Application for a non-material amendment following a grant of planning permission.

Single Storey Side Extension	
Reference number:	LU/71/21/HH
Date of decision	05/05/2021

Window size changes to front & rear elevations

PROPOSED FLOOR PLANS AND ELEVATIONS

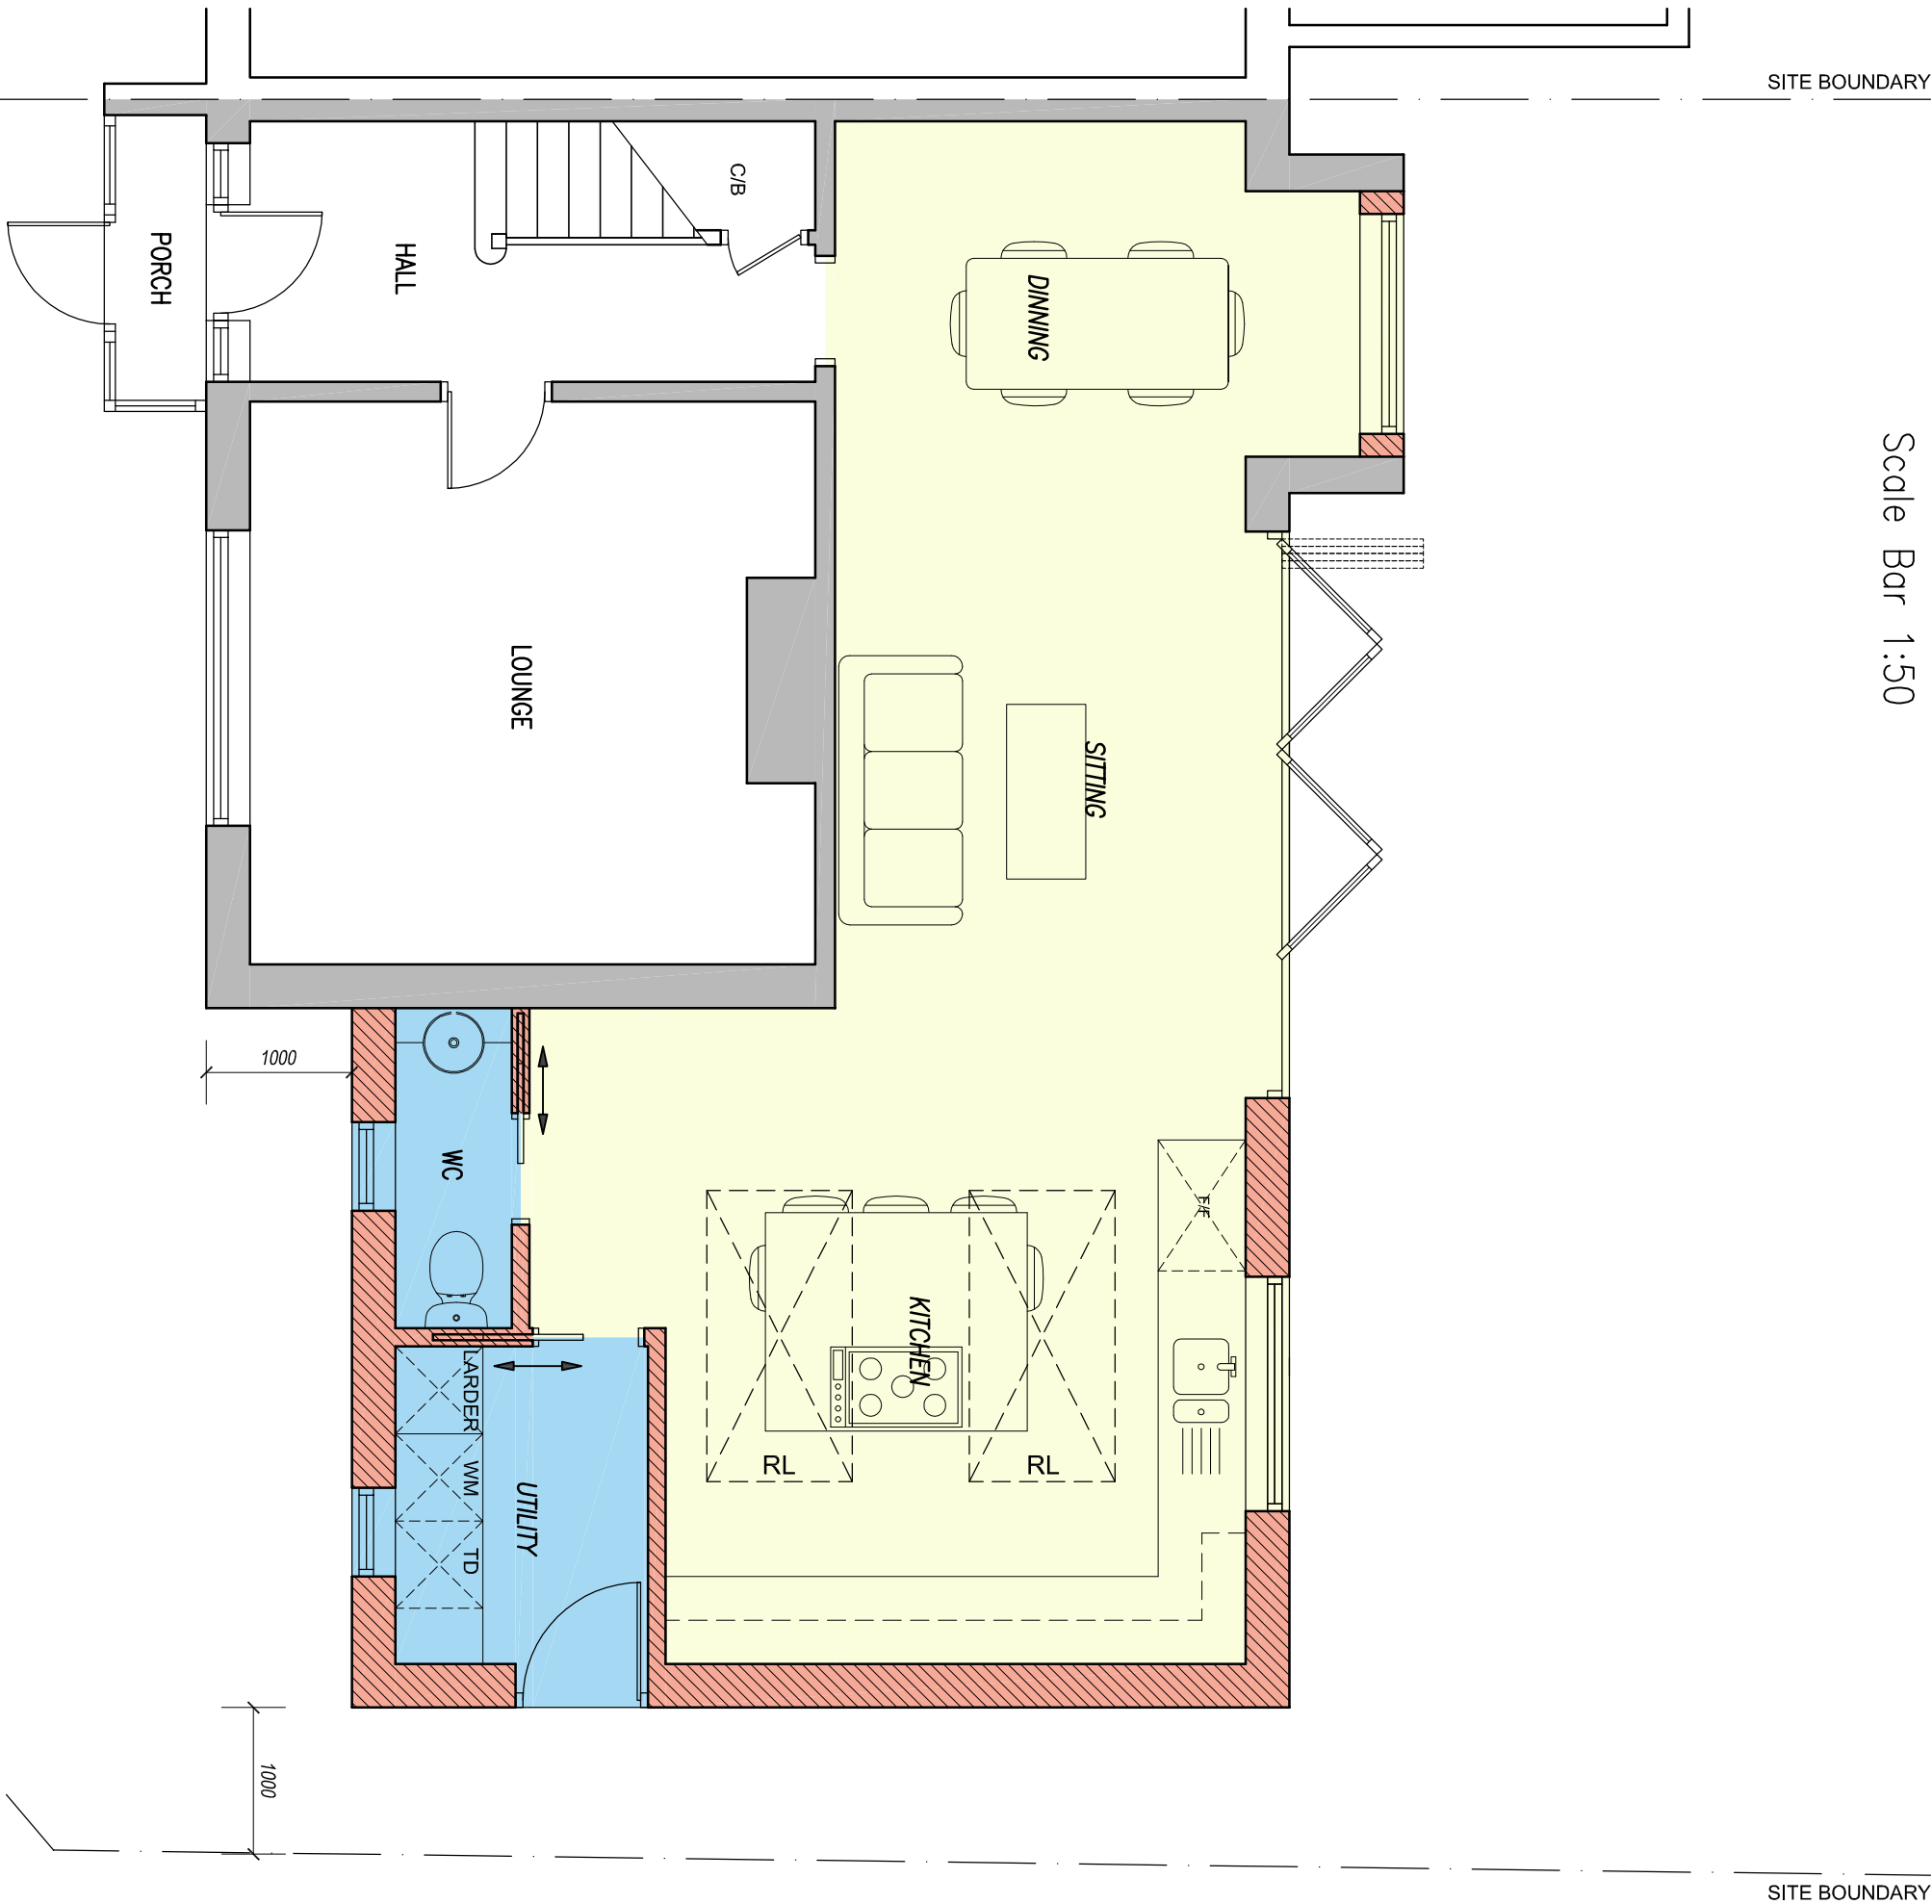
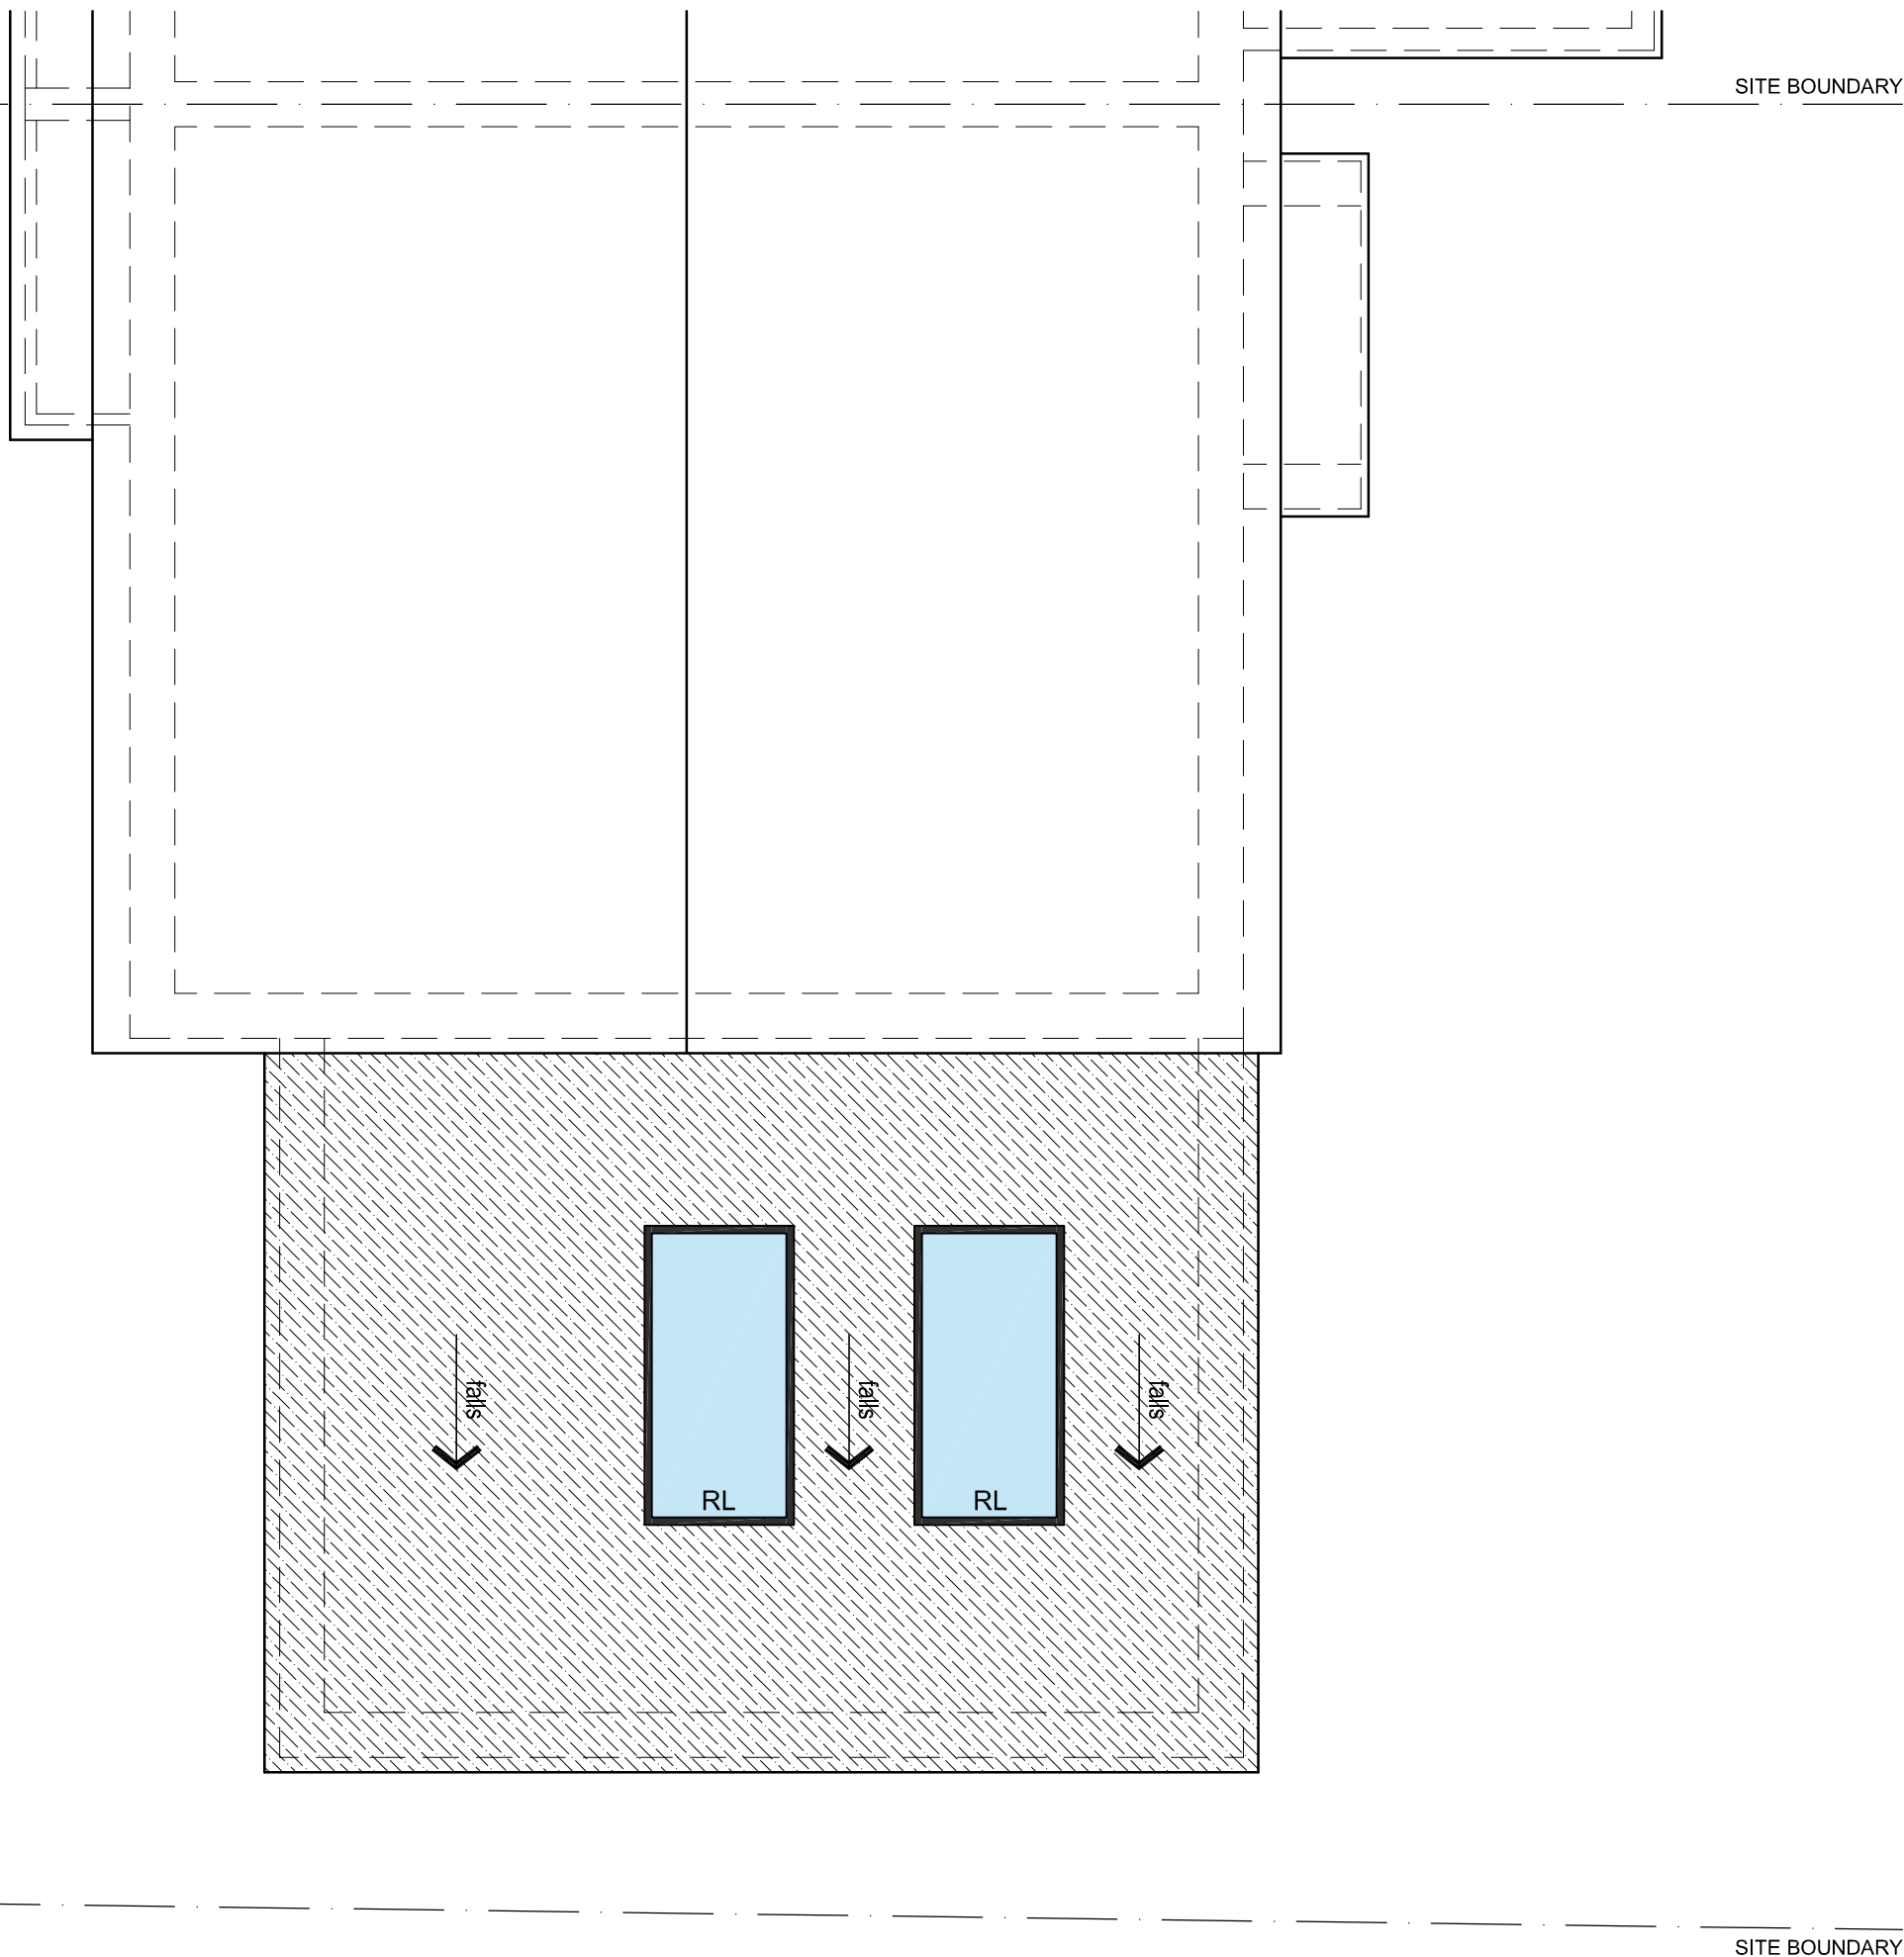
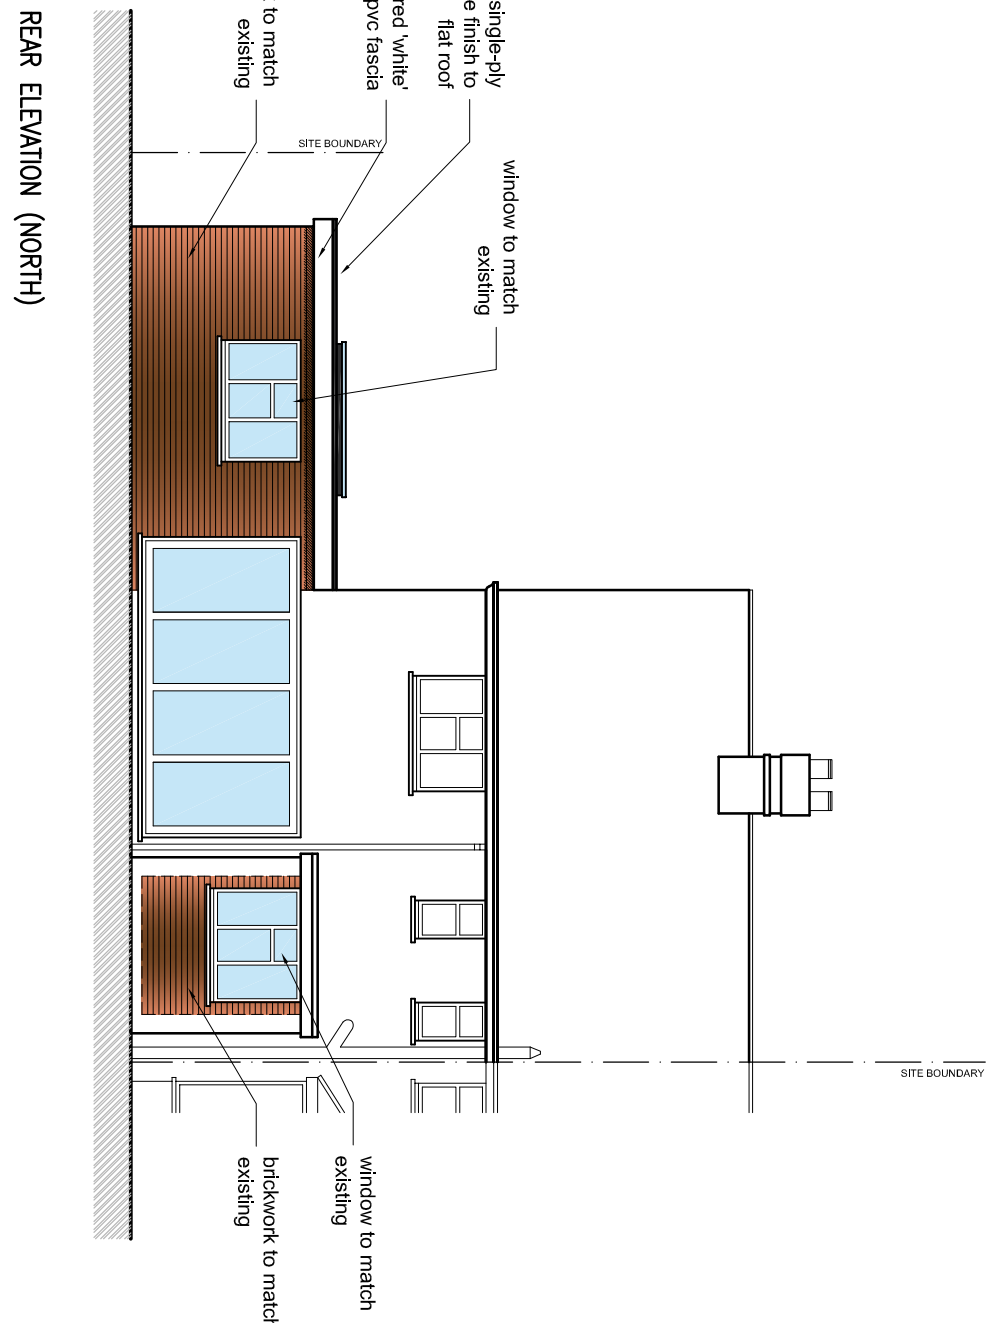
Internal layout changes

3353_12A_Proposed Floor Plans and Elevations
